Application for a non-material amendment following a grant of planning permission.
Town and Country Planning Act 1990

Non-material amendment following a grant of LU/340/17/0000
to bring first floor extension front wall forward to line
through with existing front elevation wall

Reference number: LU/340/17/HH

PLANS AS PROPOSED				 NORTH
Scale	1 : 100	@A3	drawn by	
Date	MAY 2018	checked	SM	
Drawing Number		0080 - 04		A

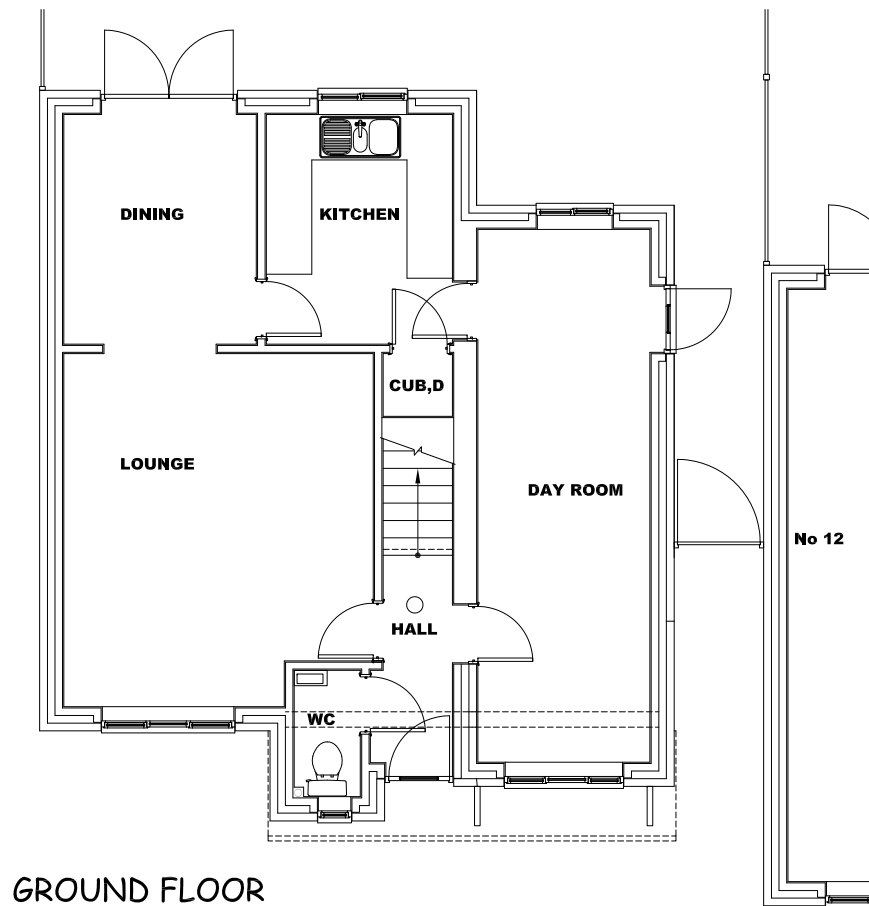
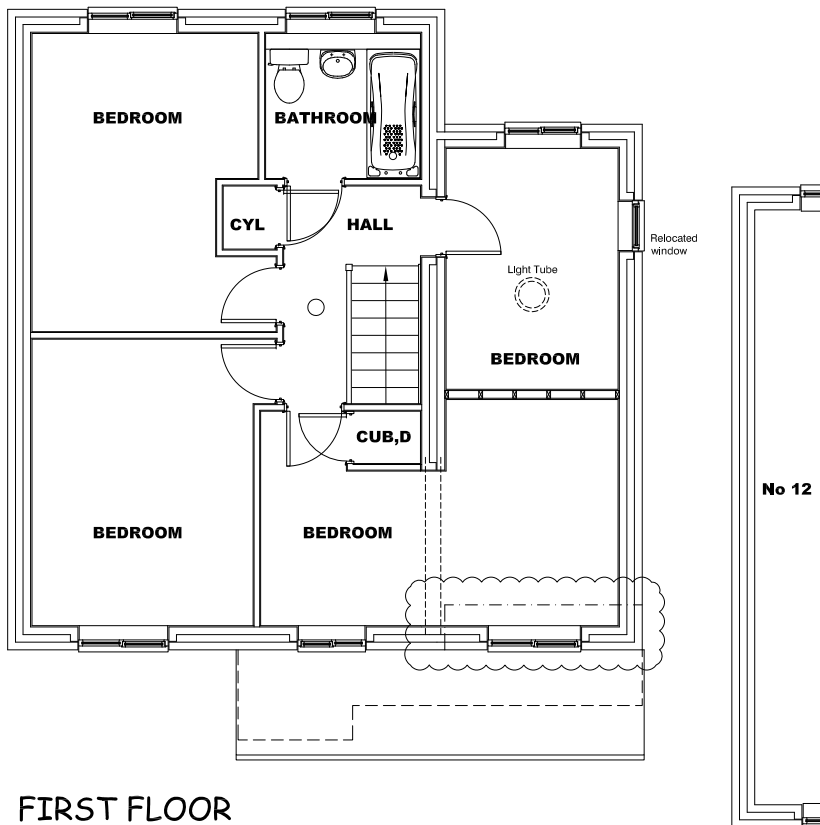
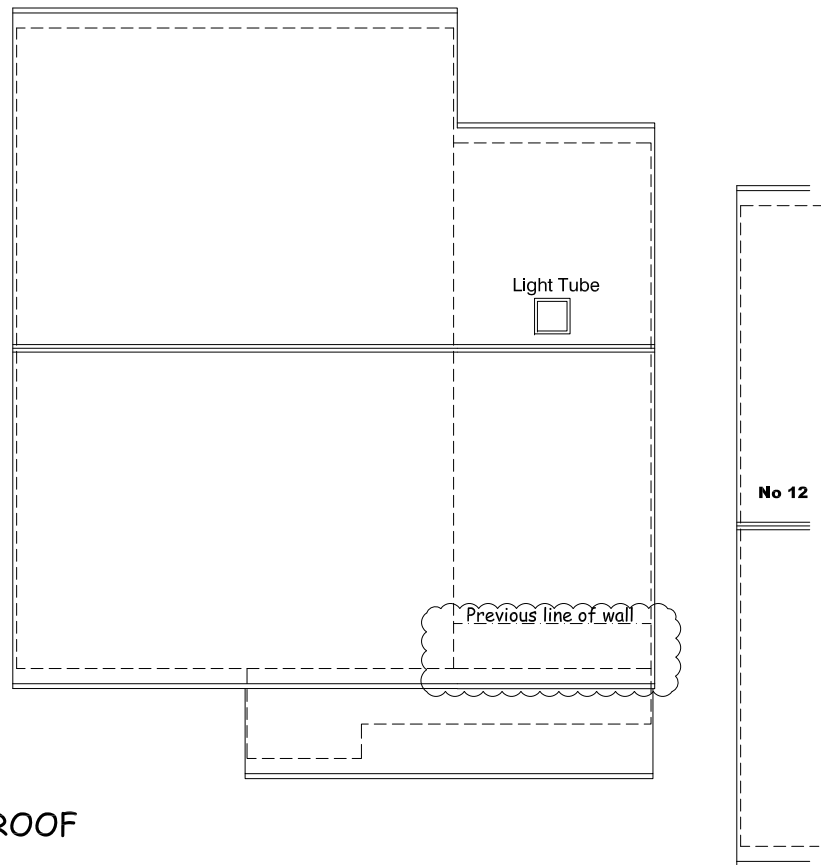
First floor extension front wall brought forward to line through with existing front elevation wall.
